David Glasgow
Principal Planner
Key Sites Assessments
Department of Planning, Industry and Environment
GPO Box 39
SYDNEY NSW 2001

SSD 9726 Adaptive Reuse of the Royal Hall of Industries

The proposal seeks approval for the adaptive re-use of the existing building to provide a new high-performance sport and community facility, along with the construction of a two-storey building, provision of vehicular entrances and the consent for the proposed land uses. The documentation in support of the proposal is reviewed and comments are provided as follows.

Figure 7 Bike parking location

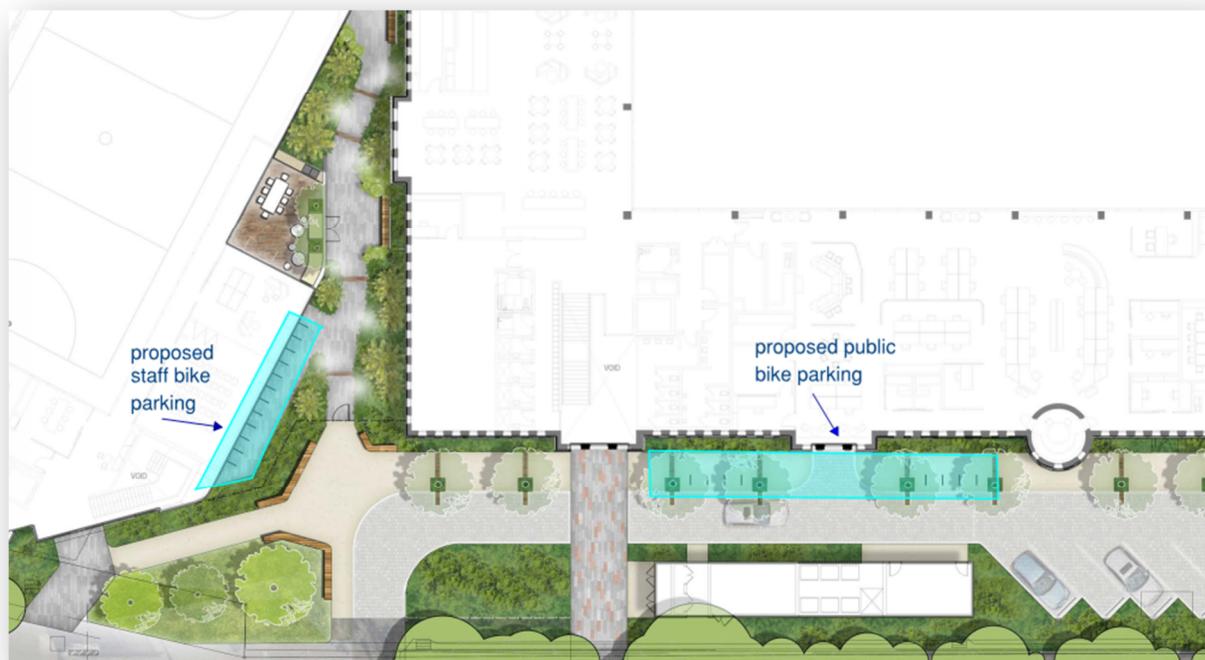
Further, limited information has been provided in the Transport Assessment report regarding bicycle parking and end of trip facilities.

- Review and provide clarification in the Response to Submissions on how pedestrian and cyclist safety would be considered; and
- Ensure that any bicycle parking facilities should be located either within the development or close to it, to support and encourage active transport access to the site.

DRAWING NO. N165280-SK01

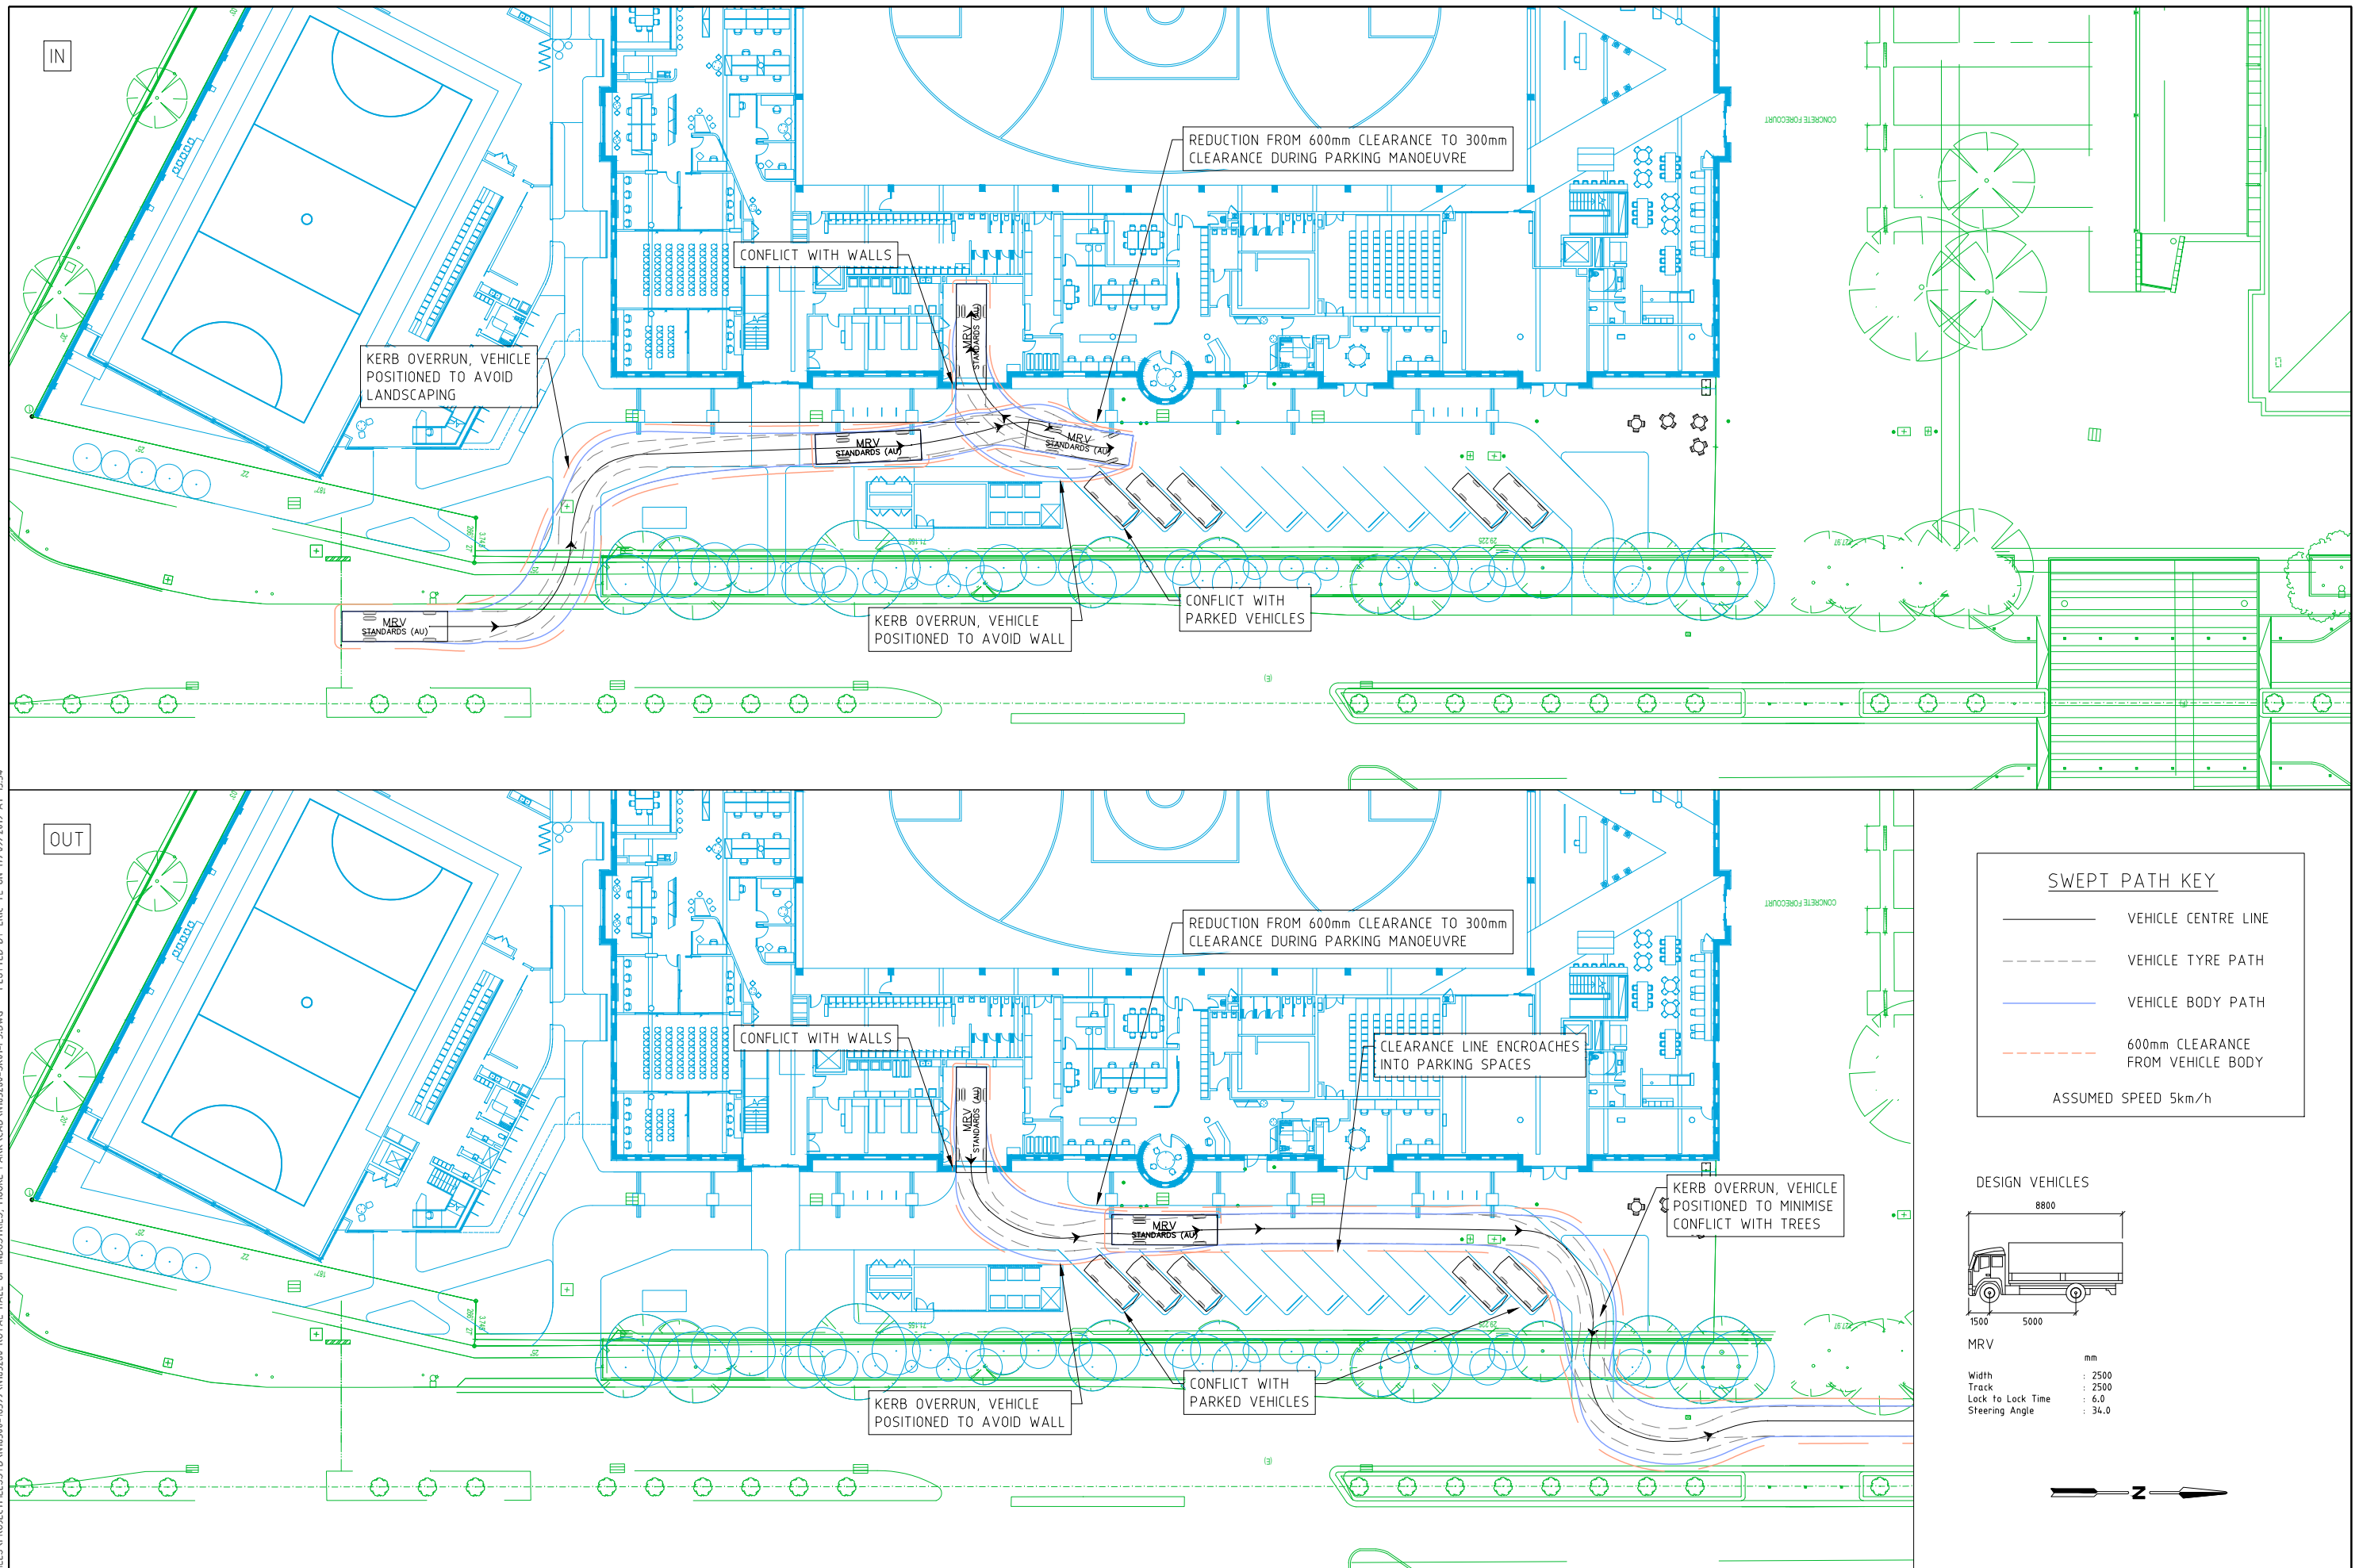
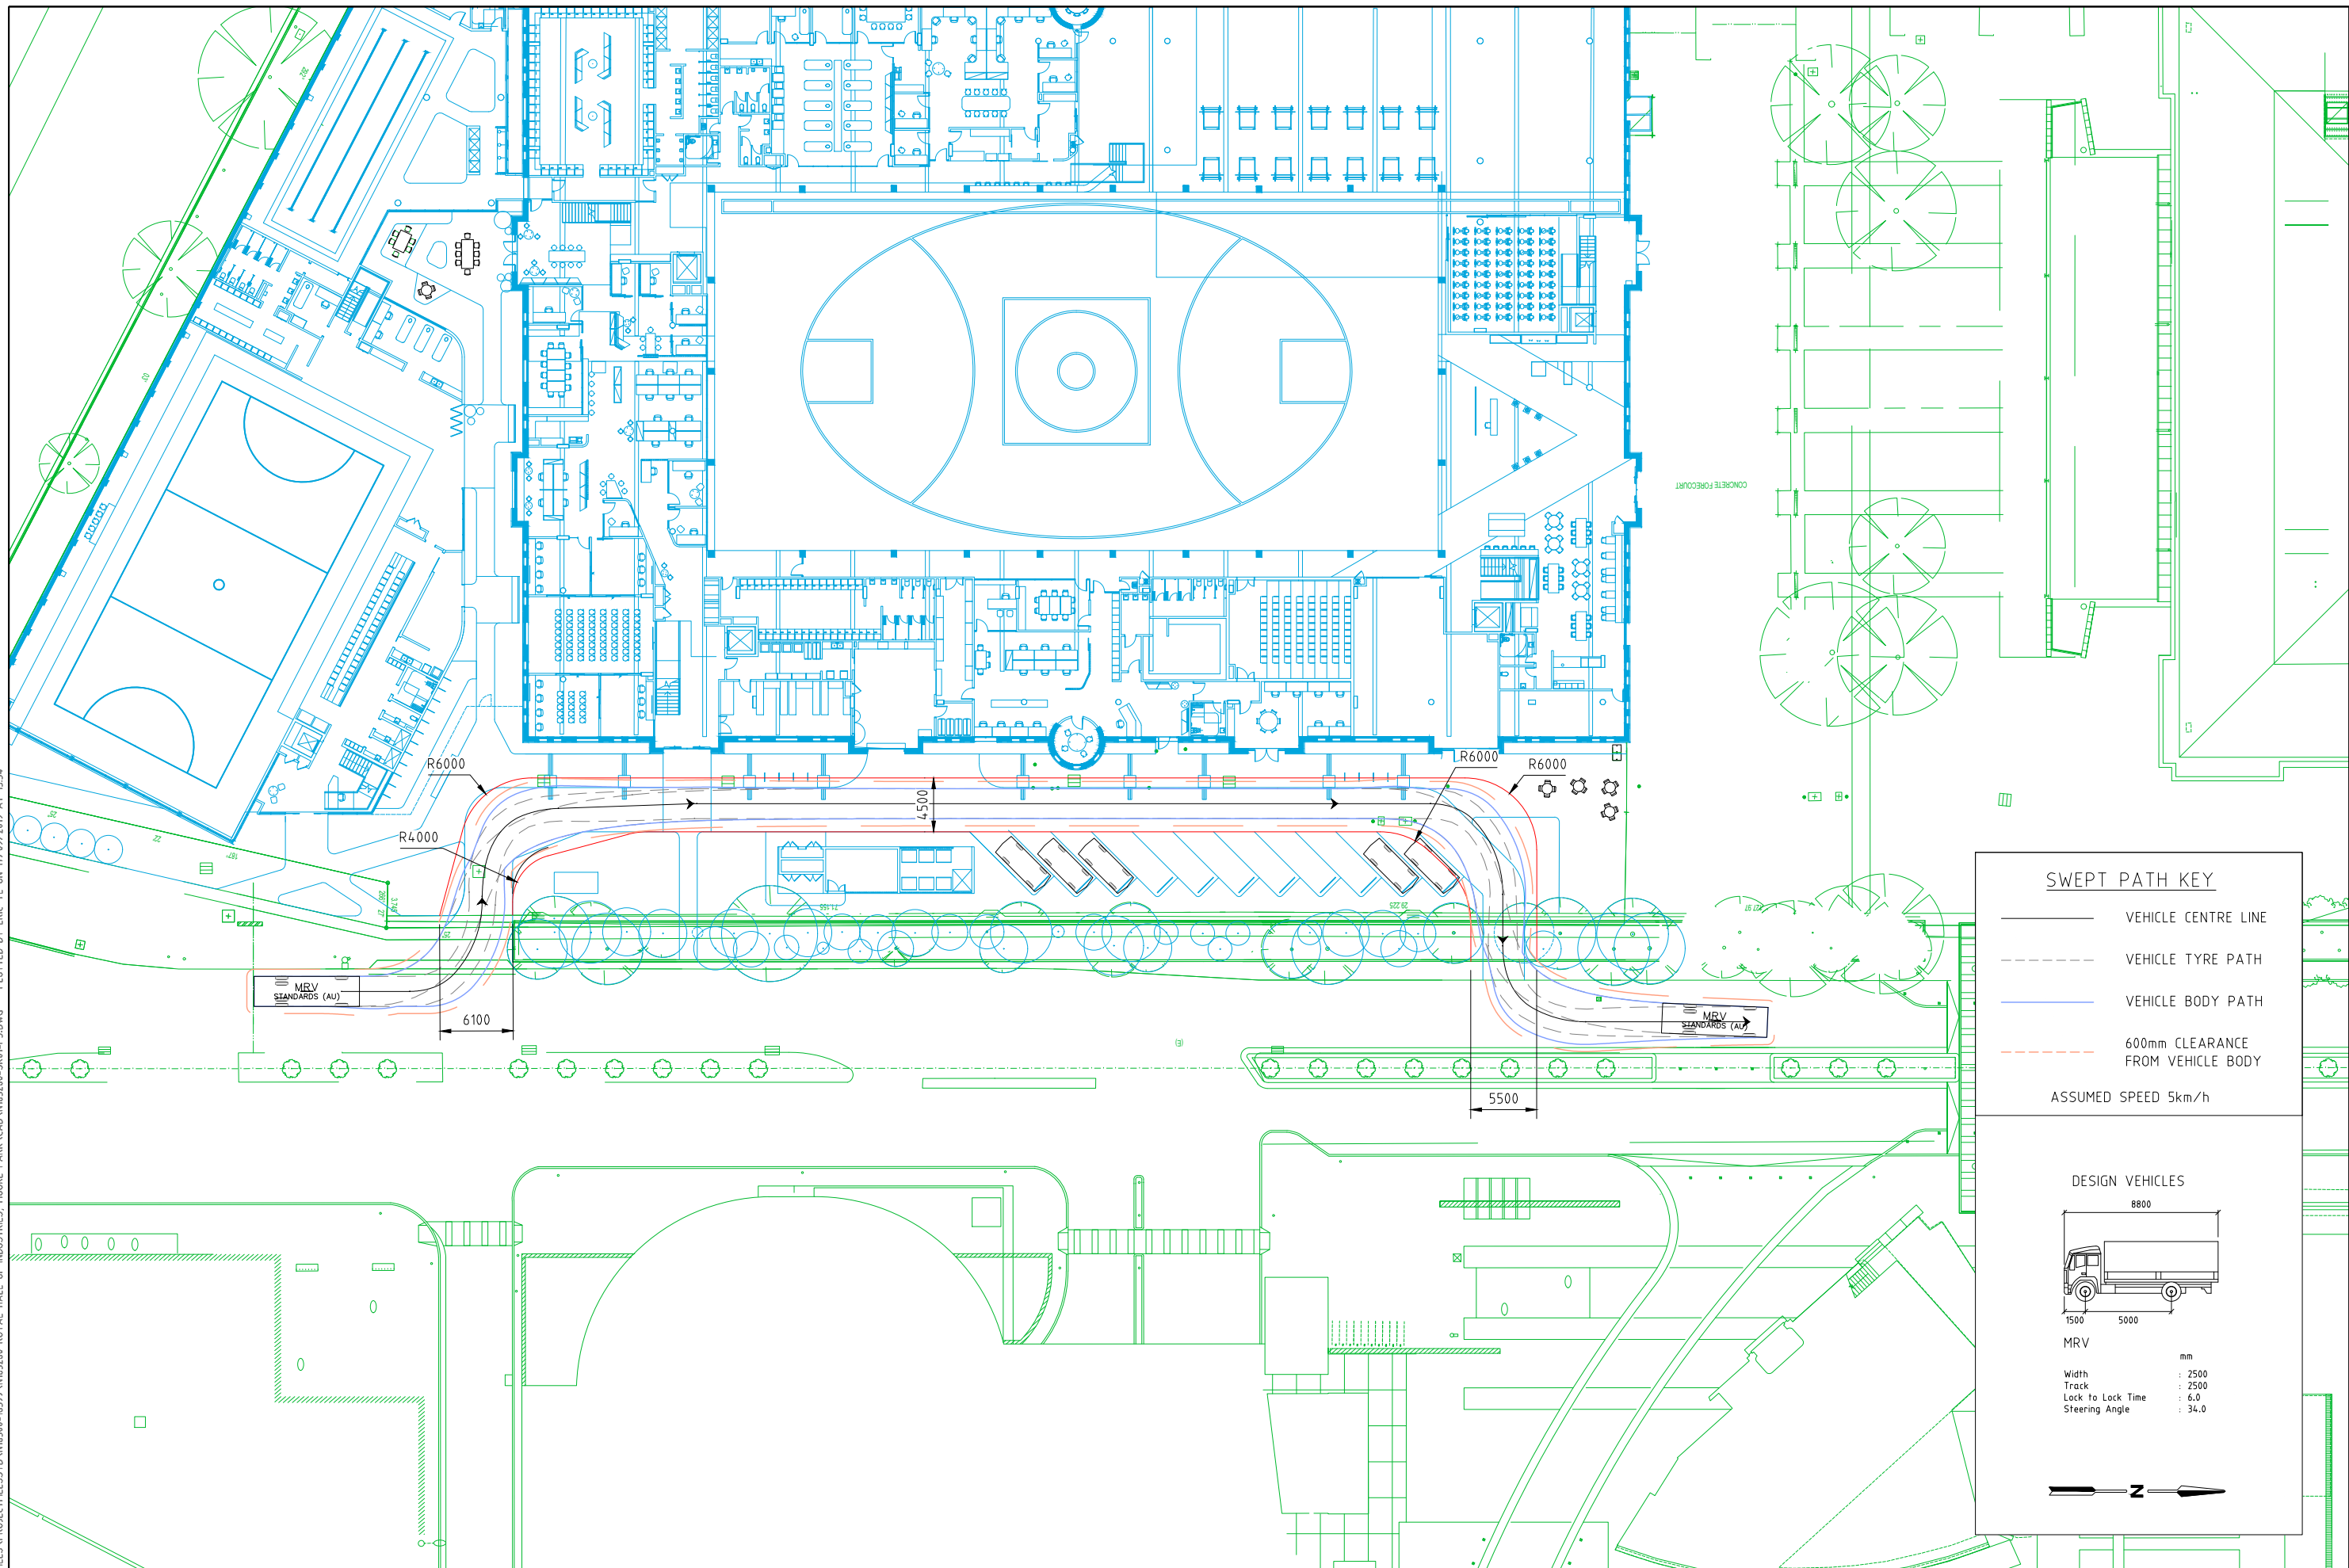
The EIS states that the proposed development includes a single loading bay suitable of accommodating small rigid vehicles up to 6.4 metres in length while the Transport Assessment report states that the loading bay would be suitable for all vehicles up to 6.8 metres. Nevertheless, the proposed loading bay size might limit future servicing of the site.

The EIS also states that the swept path analysis for service vehicles is contained within the Transport Assessment however it is not evident that such information has been included.

Swept path analysis for service vehicle access should also be included in the Response to Submissions.
